DFT PR-2024-010446

SI-2024-00774

RESPONSE TO: Code Enforcement Comments

1 ELECTRICAL SITE PLAN

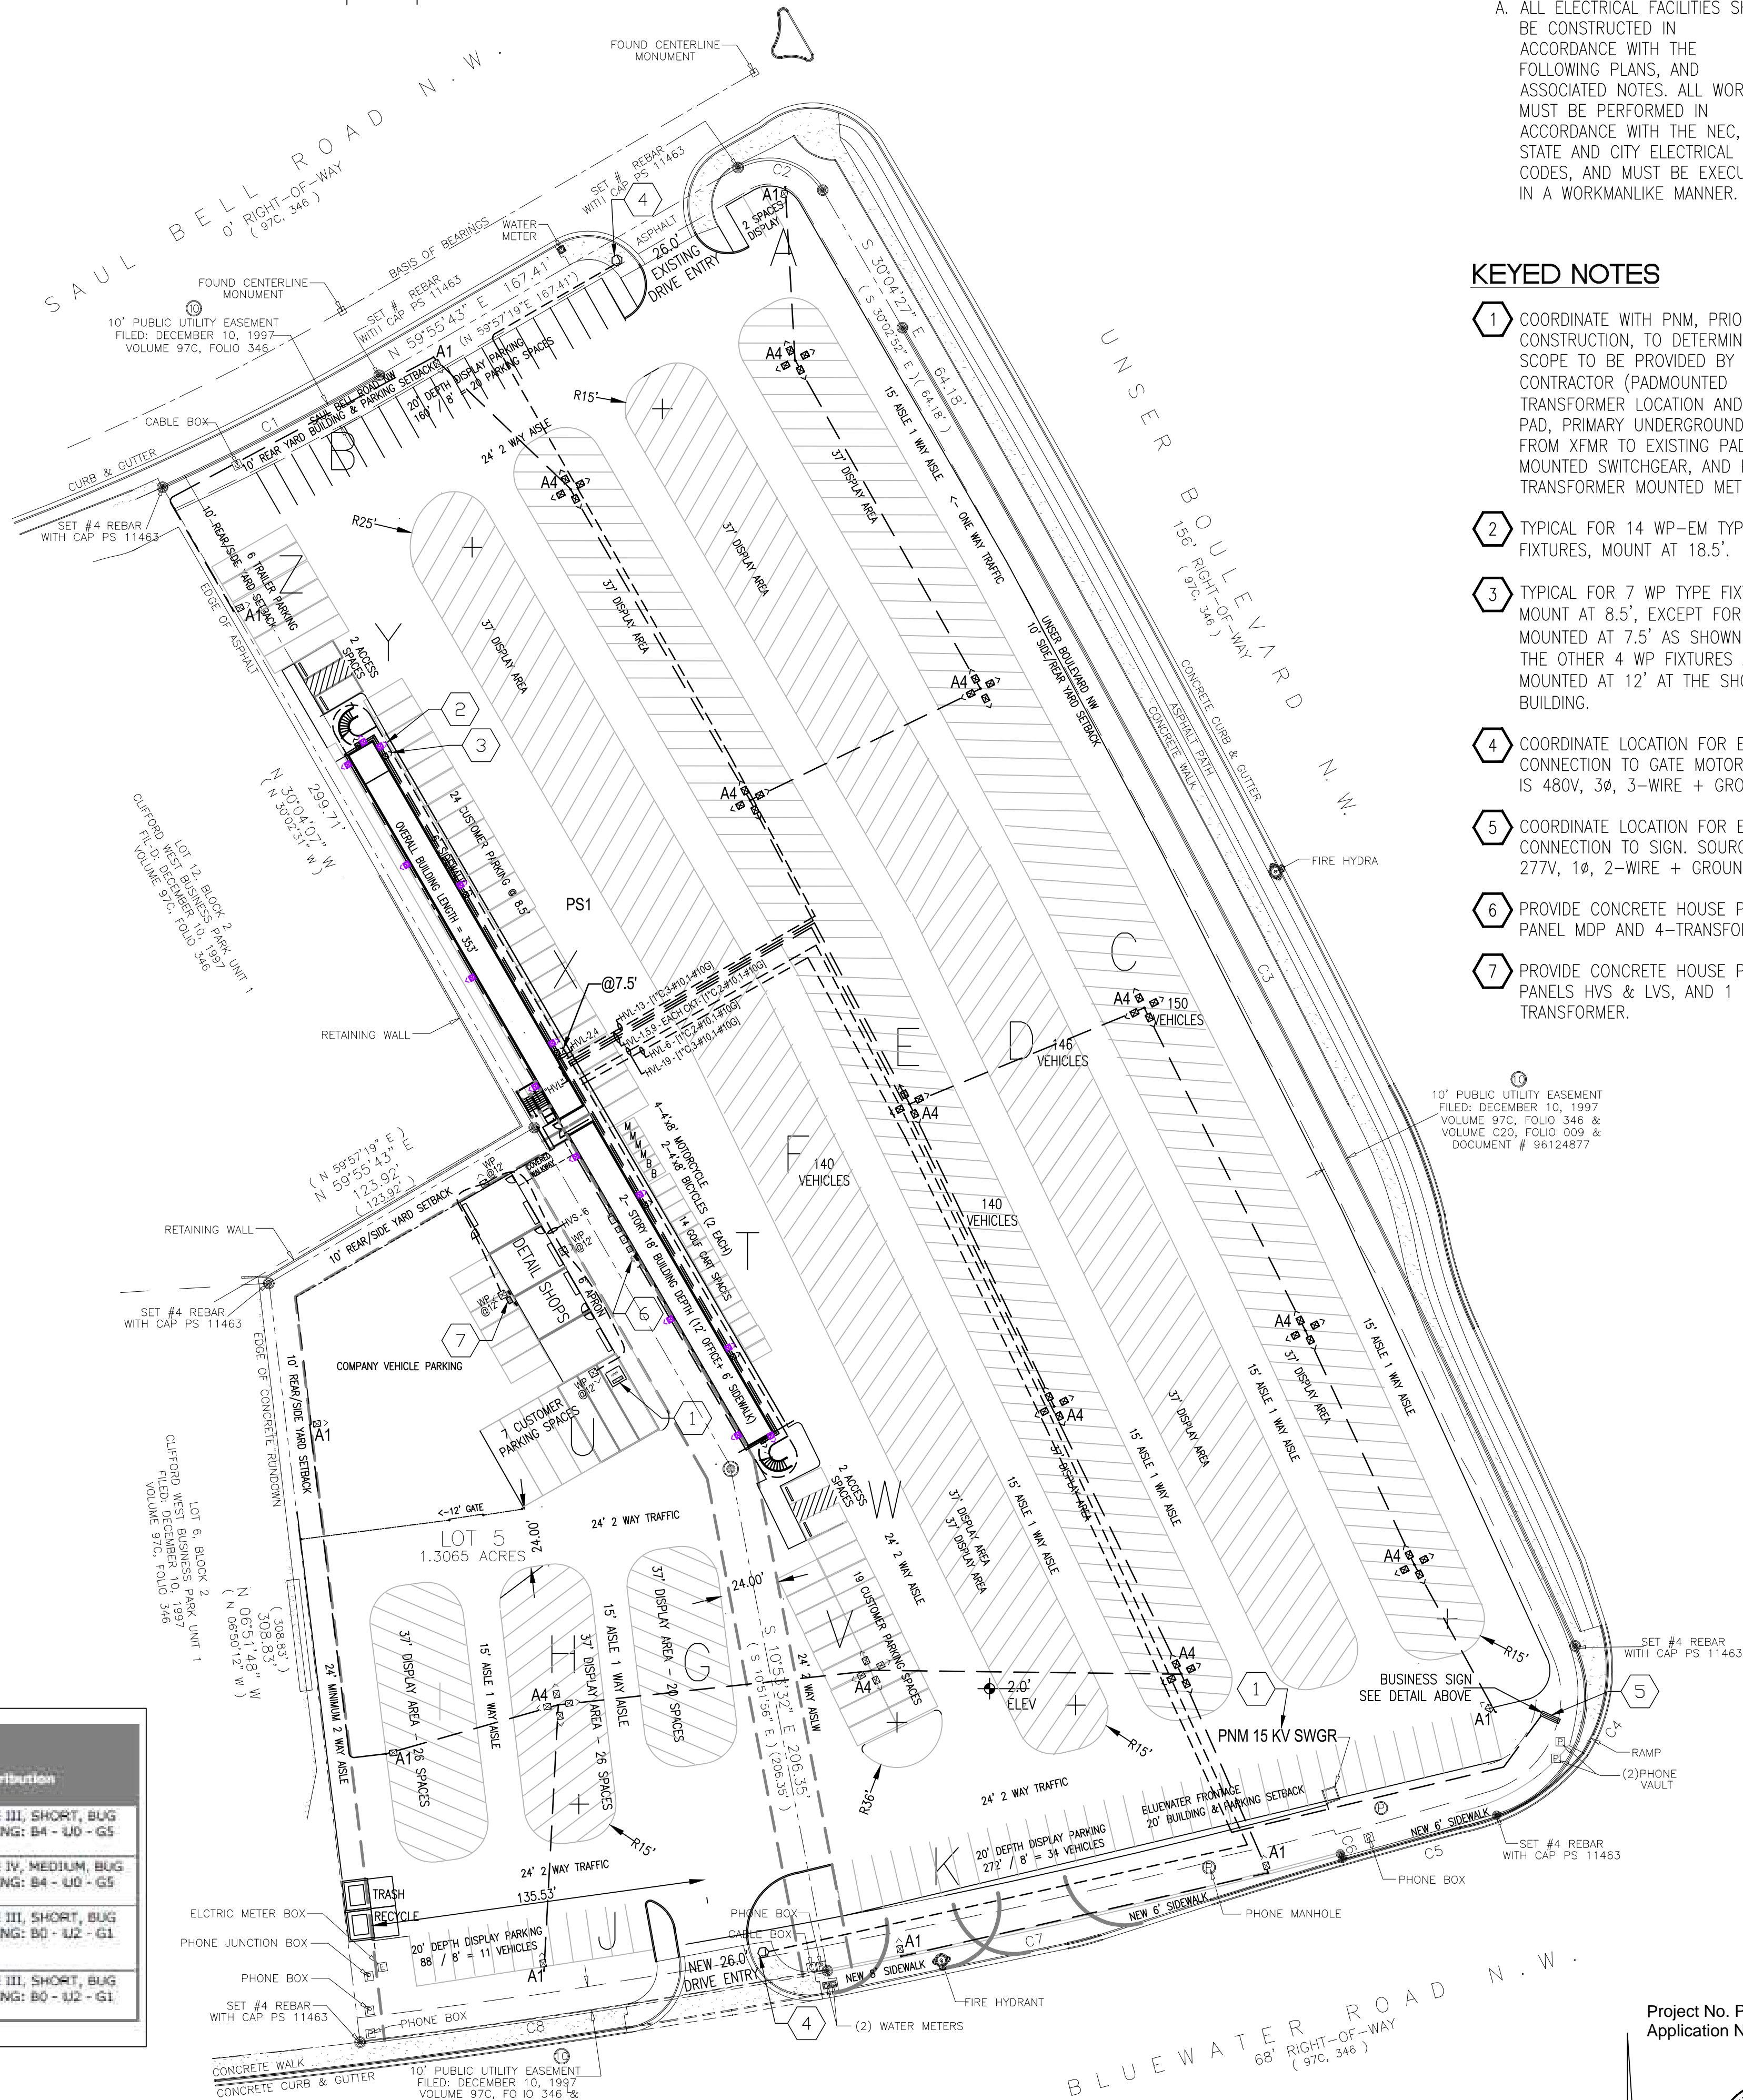
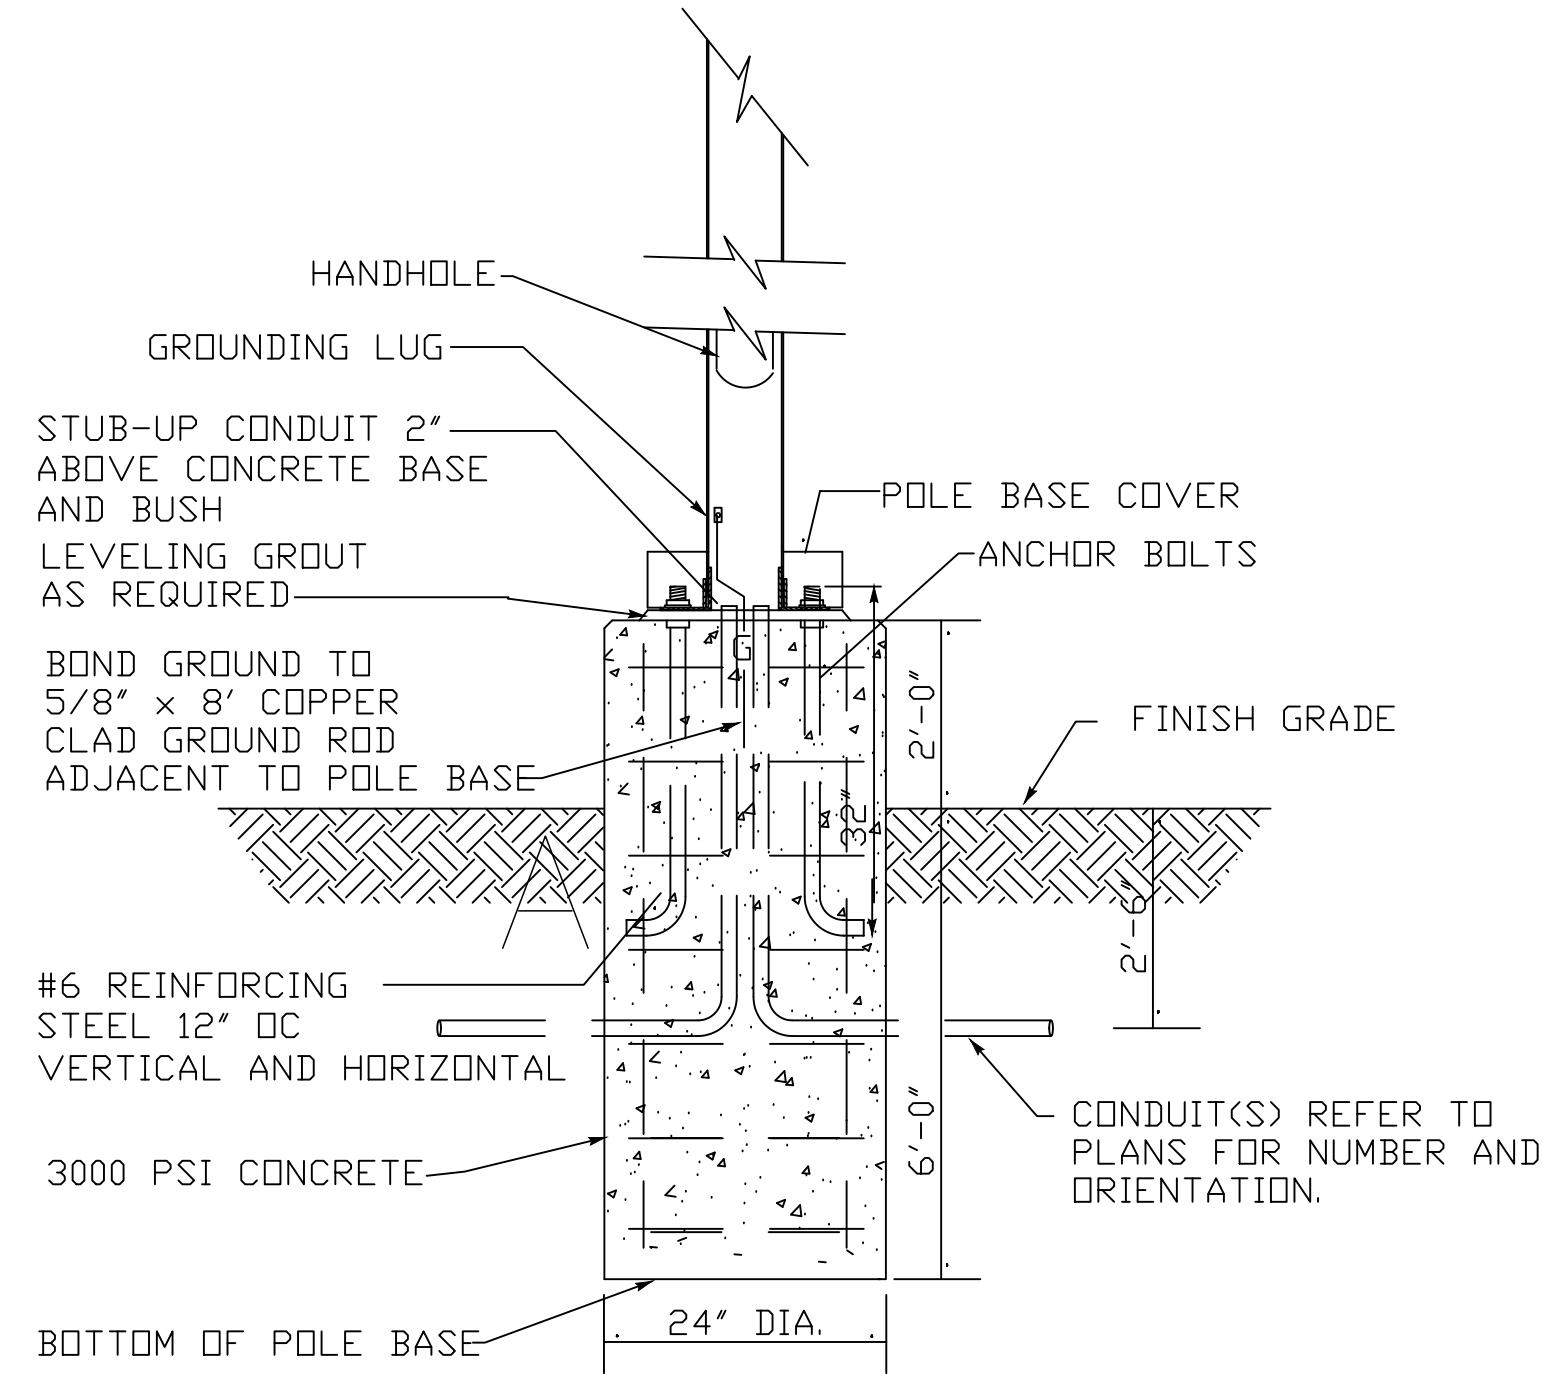
2. --Lighting plan appears to meet the standards of IDO section 5-8 from the 2022 IDO version. However, clarify how it will be meeting the CP plan.

Parking lot fixtures are to have an overall maximum height of twenty-five (25) feet. Walkway lighting fixtures are to have an overall maximum height of twelve (12) feet. Security lighting fixtures are not to project above the fascia or roof line of the building and are to be shielded. The shields are to be painted to match the surface to which attached. Individual site lighting standards should blend with the architectural character of the building and other site fixtures.

▪ **Provide a lighting plan with dimensions that meet the Clifford plan requirements.**

RESPONSE: See sheet E1 for the Pole Base Detail and fixture specifications. All outdoor pole mounted fixtures will be set at 25' maximum above ground. Luminaires have integral cutoffs to control the horizontal projection of fugitive illumination. See the pole mounted luminaire and wall mounted fixture exterior lighting will be automatically controlled for ON/OFF operation.

The exterior area lighting plan **Sheets E1 and Supplements 1 and 2** have been clarified to improve the readability of illumination levels and dispersion patterns. (Enclosed)

ADDITIONAL RESPONSE: The CWMP Section LIGHTING standards for 25 foot tall pole mounted parking area lighting has been implemented. Walkway fixtures on the Office Building are flush mounted into the underside soffits of the balcony and the roof eave projection. Wall mounted lighting fixtures on the Shop Building are set at 12’ above grade. The exterior pole mounted area lighting and building mounted circulation lighting was designed in compliance with the IDO 2023 Edition. The exterior area lighting plan Sheets E1 and Supplements 1 and 2 have been clarified to improve the readability of illumination levels and dispersion patterns. (Enclosed Rev. E1, Supp.1&2). Luminaires are shielded to cutoff light spread and regulate lighting intensity levels as required by IDO 5-8(D)(1)(a).

Copyright 2024 Mitchell Associates Inc. All rights reserved.  
PROJECT No: 2024-061  
**LS-101**

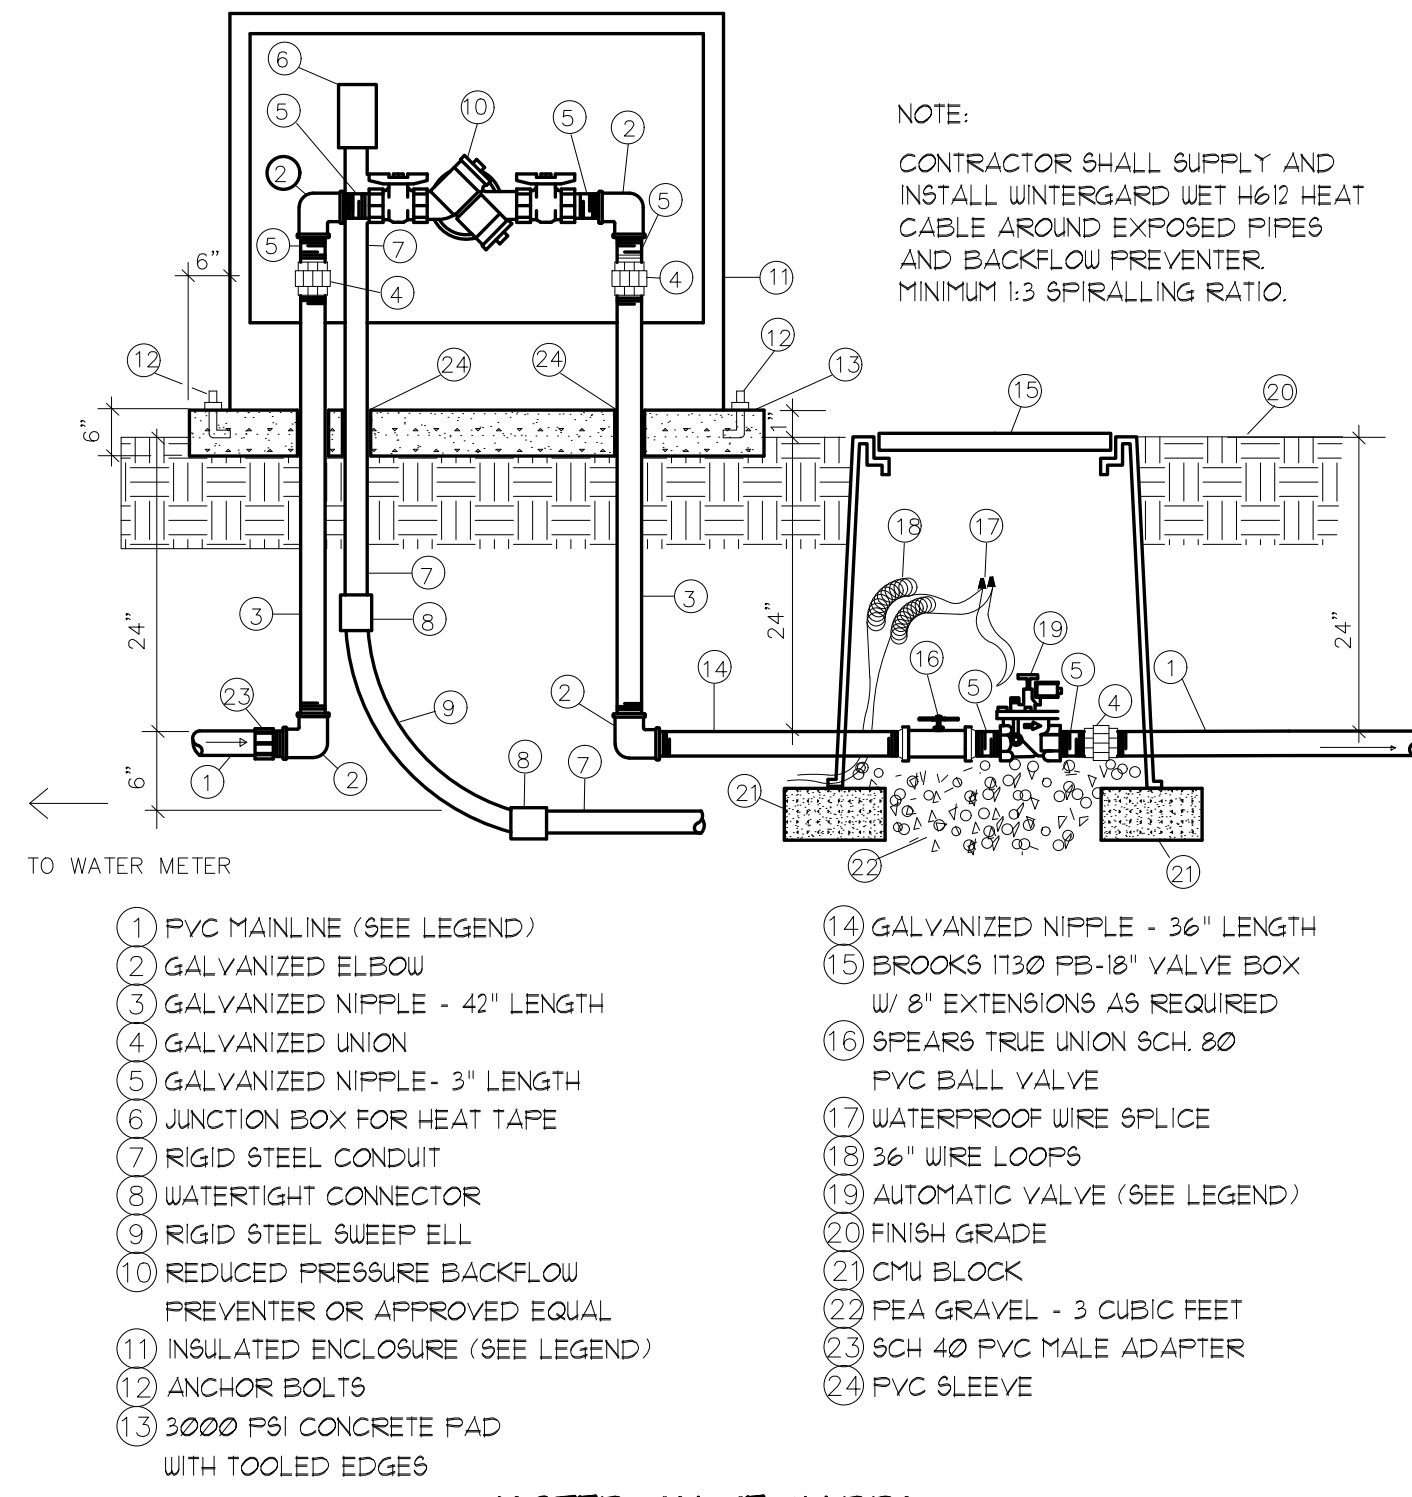
- **Clarify and confirm that all development, landscaping, and screening are on private property, and they do not encroach into the public right of way. Clarify if dedication of right of way or sidewalk access easements are needed.**

ADDITIONAL RESPONSE: See the drawing Landscape Plan LS-101 BERM DETAIL which shows the edges of landscaping areas in relation to the property lines right of way boundaries. All development will occur within the property boundaries. The only exception being the CWMP requirement that the landscaping areas shall commence at the back of the street curb, therefore requiring that new landscaping is to be installed outside the property lines abutting Saul Bell, Unser and Bluewater. All sidewalk work is identified in the approved and recorded Infrastructure List. A copy is provided for review.
